Job Number: 5645

Meadowbank Education and Employment Precinct Schools Project
Response to Agency Submissions

enstruct has reviewed the authority submissions regarding the SSD-9343 Meadowbank Education and Employment Precinct Schools Project.

GRASS SWALE/ DEPRESSION DETAIL PLAN AND SECTIONS

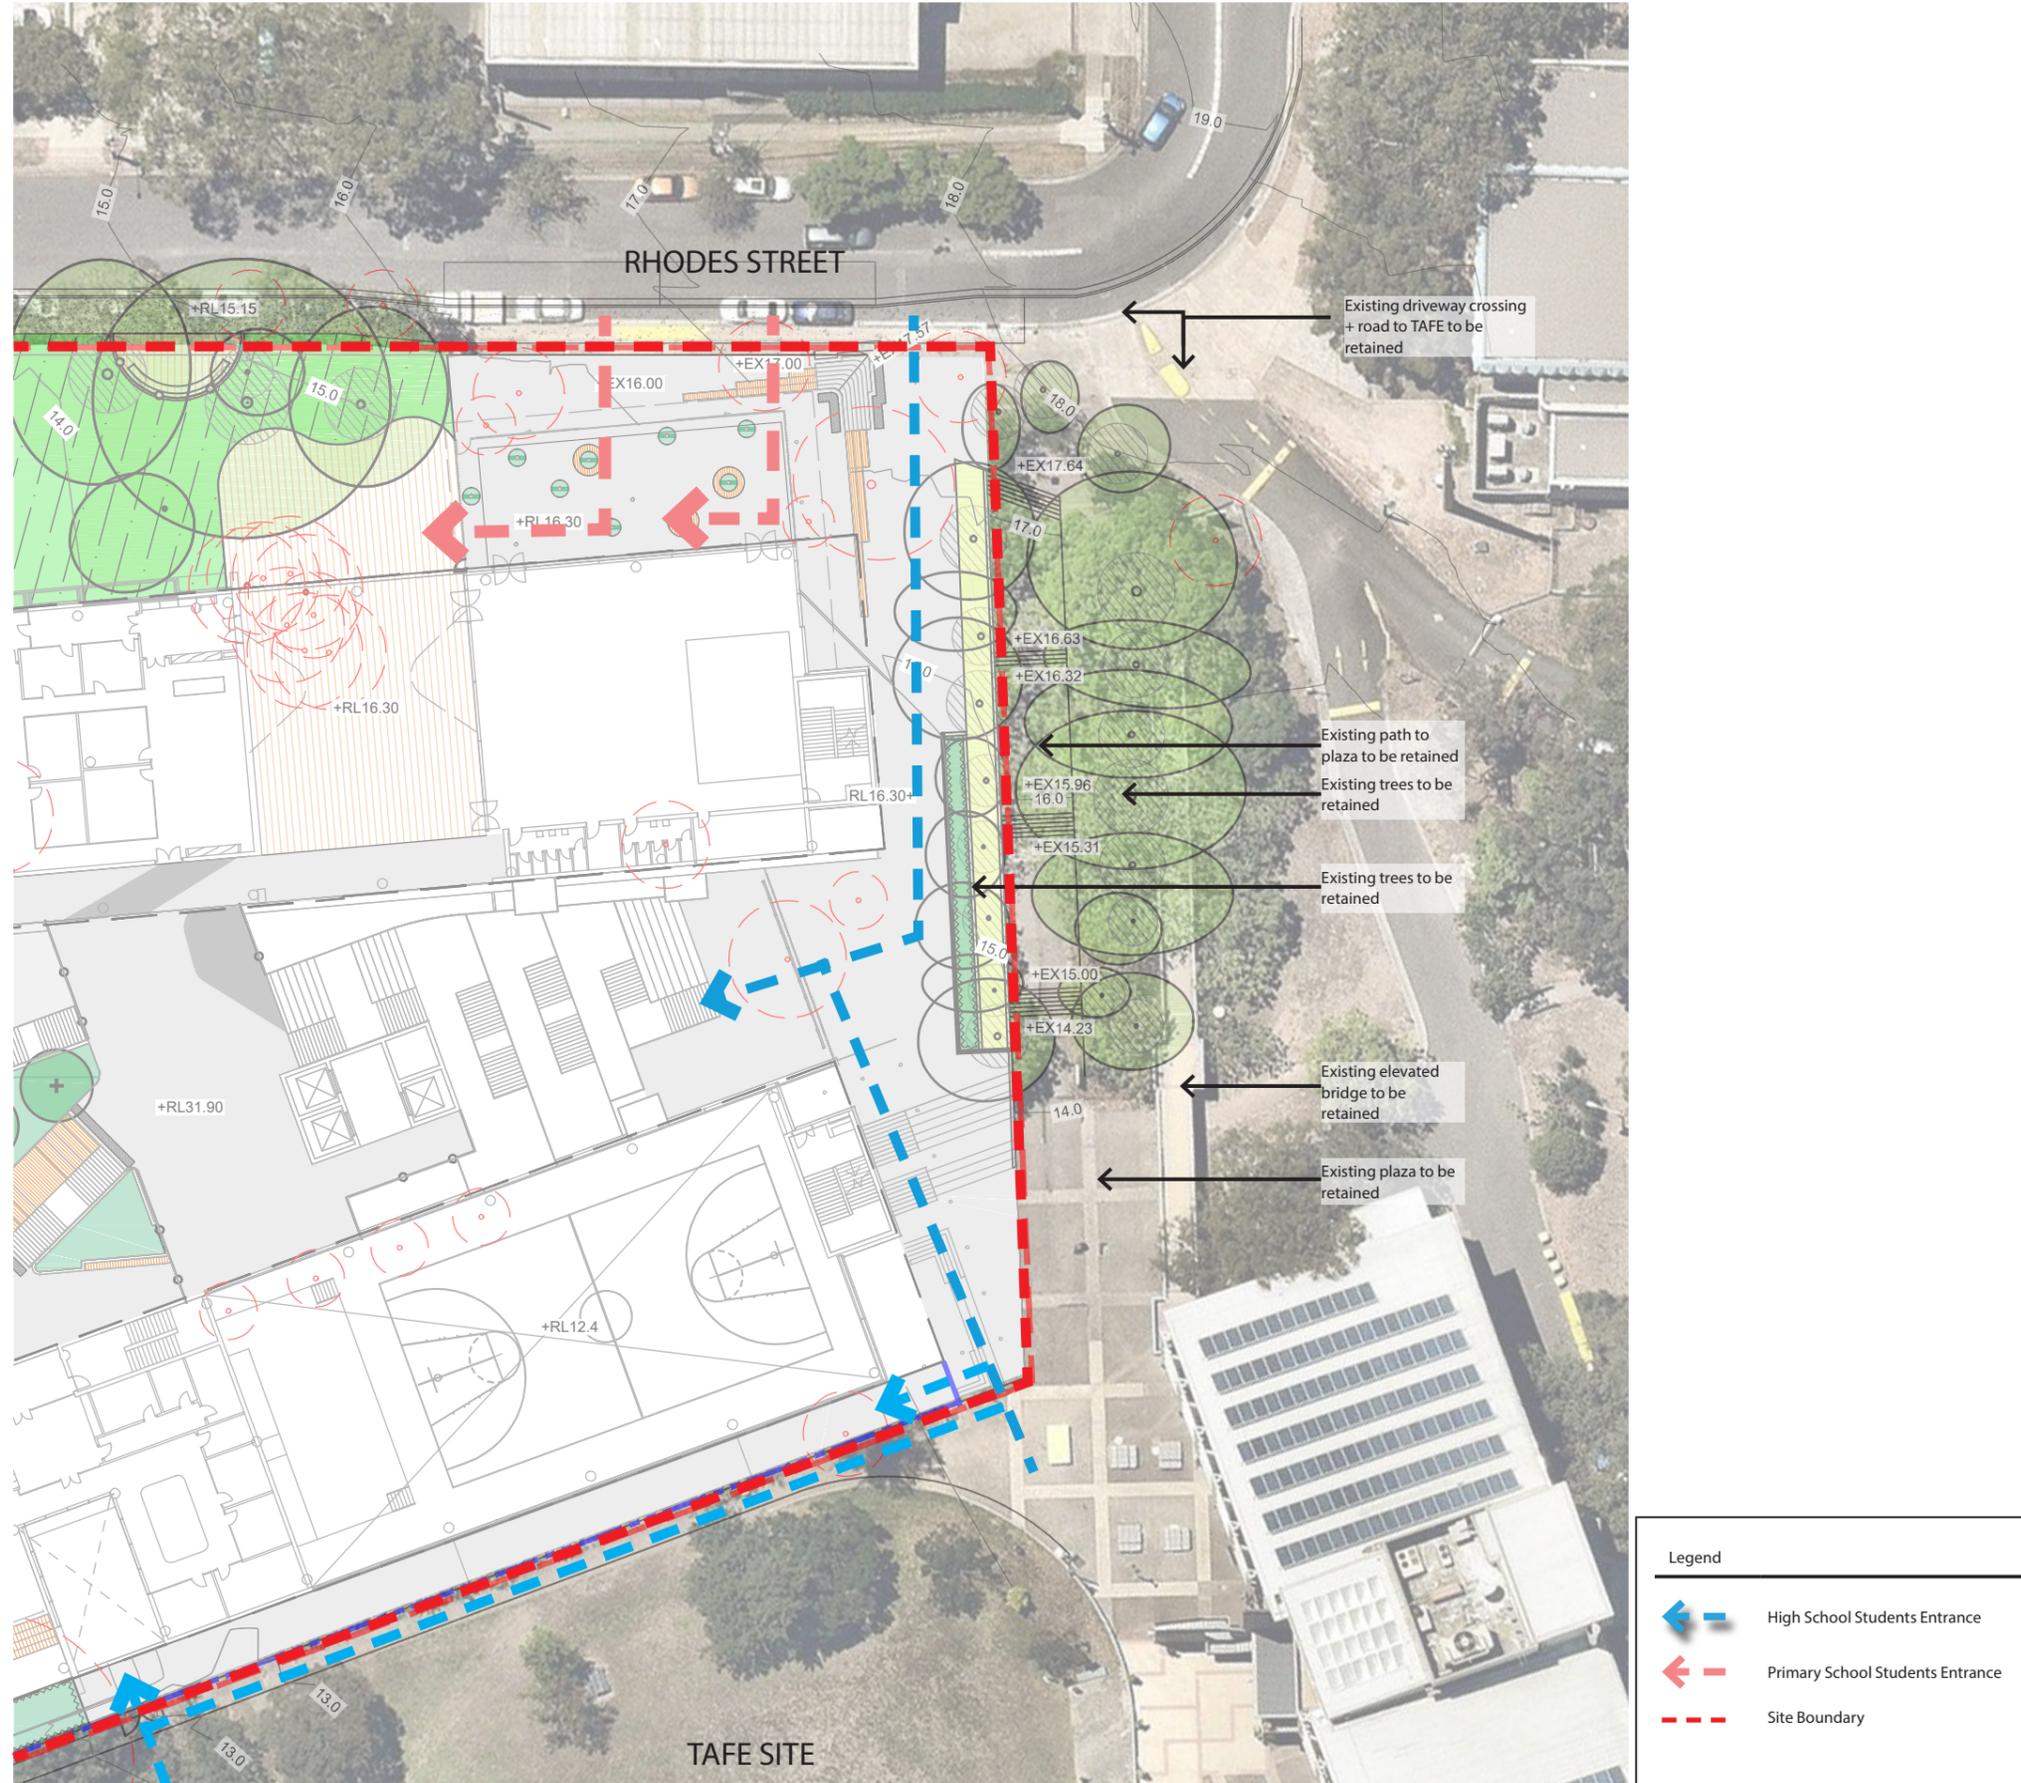
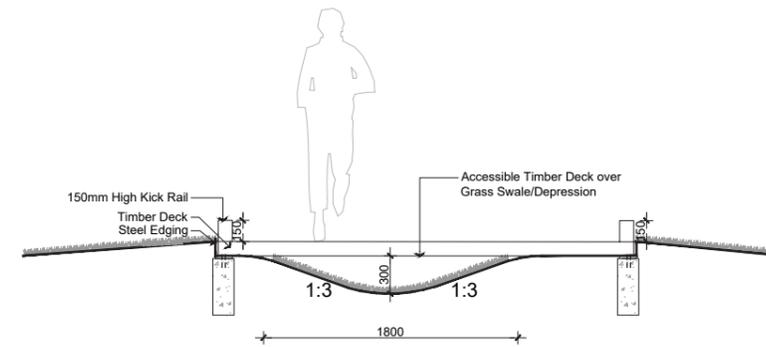
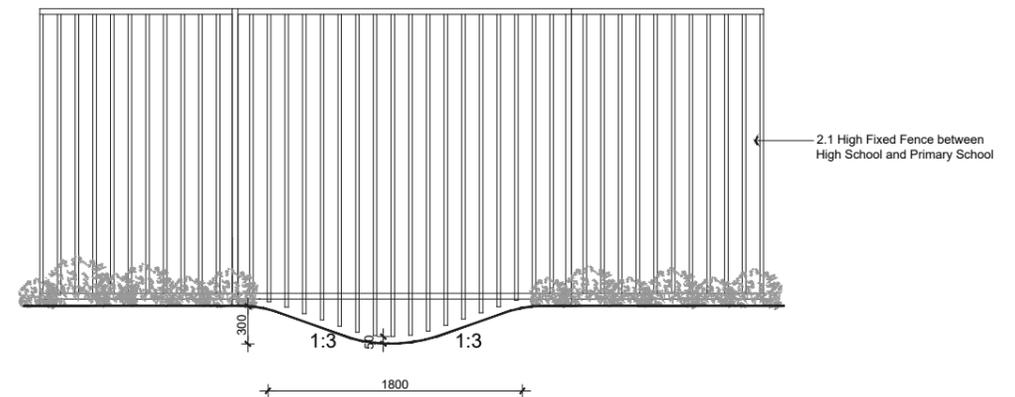
Response: Additional information has been added the Civil SSDA report, section 4.4 Flood Risk Management.
D4	Provide greater detail of the proposed swale that runs north/south through the site, including consideration of management and student safety.

Response: Additional details are provided in the landscape documentation. Part of the swale are covered by a deck, giving a crossing location.
EES	Environment Energy and Science Group in the Department of Planning, Industry and Environment.
C1	The proposed school can be classed as a special uses' facility due to the vulnerability of its users (i.e. the students). Therefore, it is prudent to adequately address flood risk for the full range of flood up to the PMF, particularly risk to life. The Civil Report outlines the flood characteristics; however, it does not address the associated flood risk due to the exposure to flooding with these characteristics.
